Subject: RE: Mayflower Way, Angmering: Planning Consultation A/46/19/PL-Drainage Conditions

The details submitted indicate that a drainage solution should be obtainable with the proposed layout. Final drainage details can be secured by conditions.

Drawing Title
**Engineering Details
Longitudinal Sections**

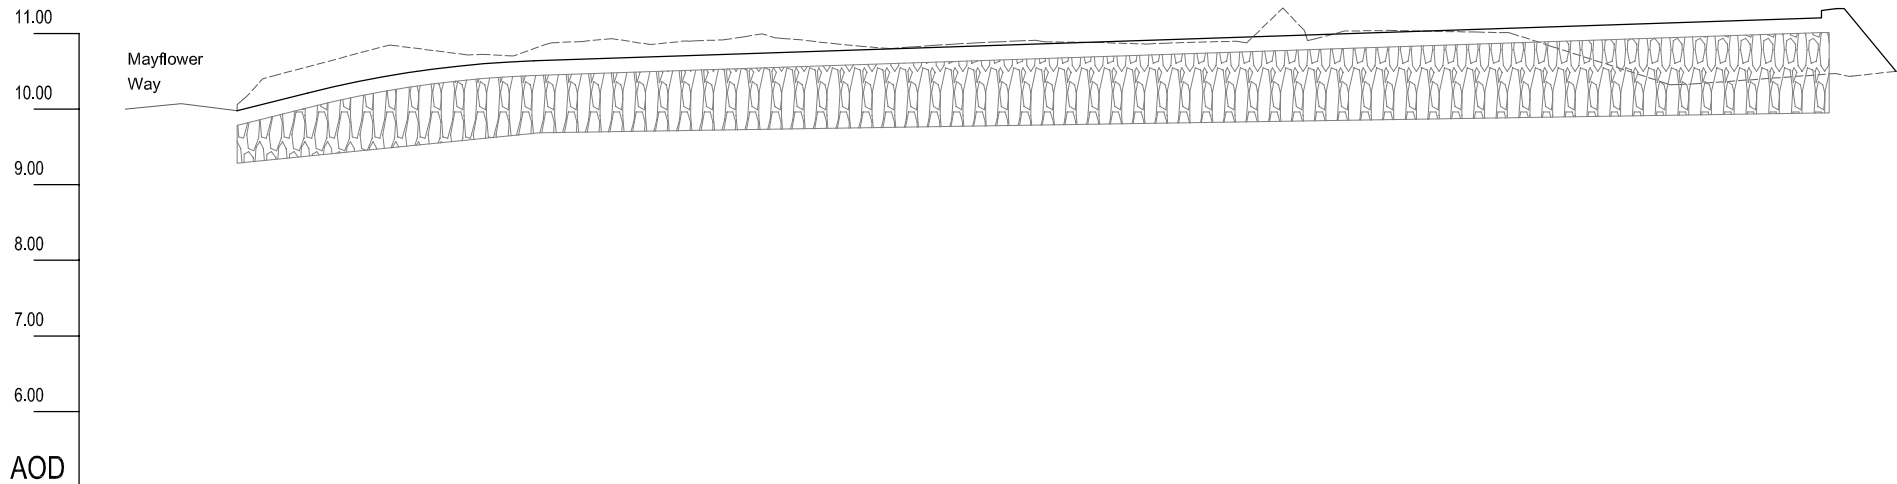
I've had a look and permeable driveways and ch0-20 okay.
